Case Officer: Hannah Kersley
Reference: AW/80/22/T
Location: Malmayne Court, Aldwick Fields, Aldwick, PO21 3SW
Proposal: 1no. Monterey pine (03007) -fell due to weakened trunk from large branch falling in the storm. 1no. Monterey pine (03008) Crown lift low branches back to main stem to give 3m head clearance. 1no. Monterey pine (03009) - remove deadwood in crown
Reasons given: Health and safety

03007, 03008 & 03009 all Monterey Pine

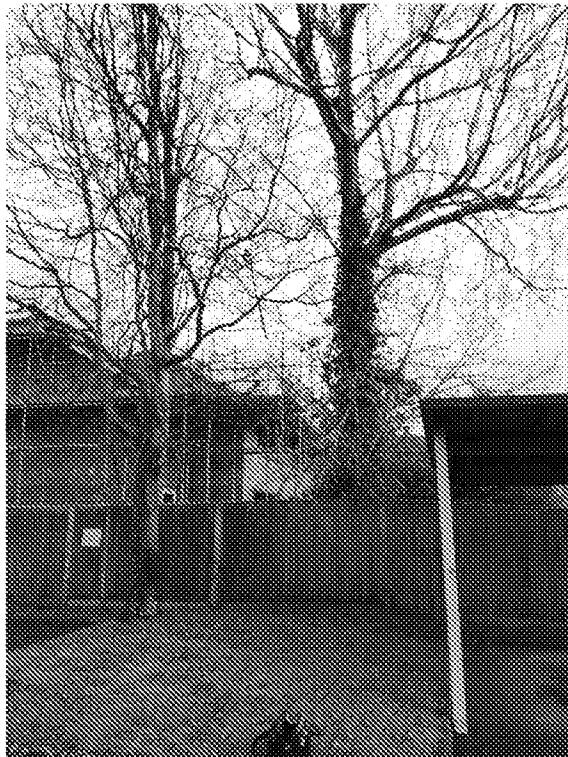
- T7 and T8 are in fine physiological condition. They have attractive crown profiles which mask several structural imperfections (multiple stems and their subsidiaries). T7 has recently sustained a deep tear-out wound on main stem following storm damage. Although not hazardous the long-term structural integrity of the tree is compromised.

- Only T7 (03007) requires approval from the local planning authority. Although the tree remains healthy and viable for safe retention, long-term prospects are not good.
- It occupies a prime position for a high value tree, offering considerable visual amenity to a wide audience. A suitable replacement can be secured by a condition, ensuring continuity of this arboricultural feature.

Once the tree has been felled (and either grubbed or ground out) then a replacement tree is to be planted in the same place or nearby and to within 5metres.

This is to be of Selected Standard Nursery Stock proportions (10-12cm girth & 2m to 3m overall height) supported on a 'short stake' system with appropriate securing ties and pads.

It is to be planted within 12 months of the removal of the pine tree.
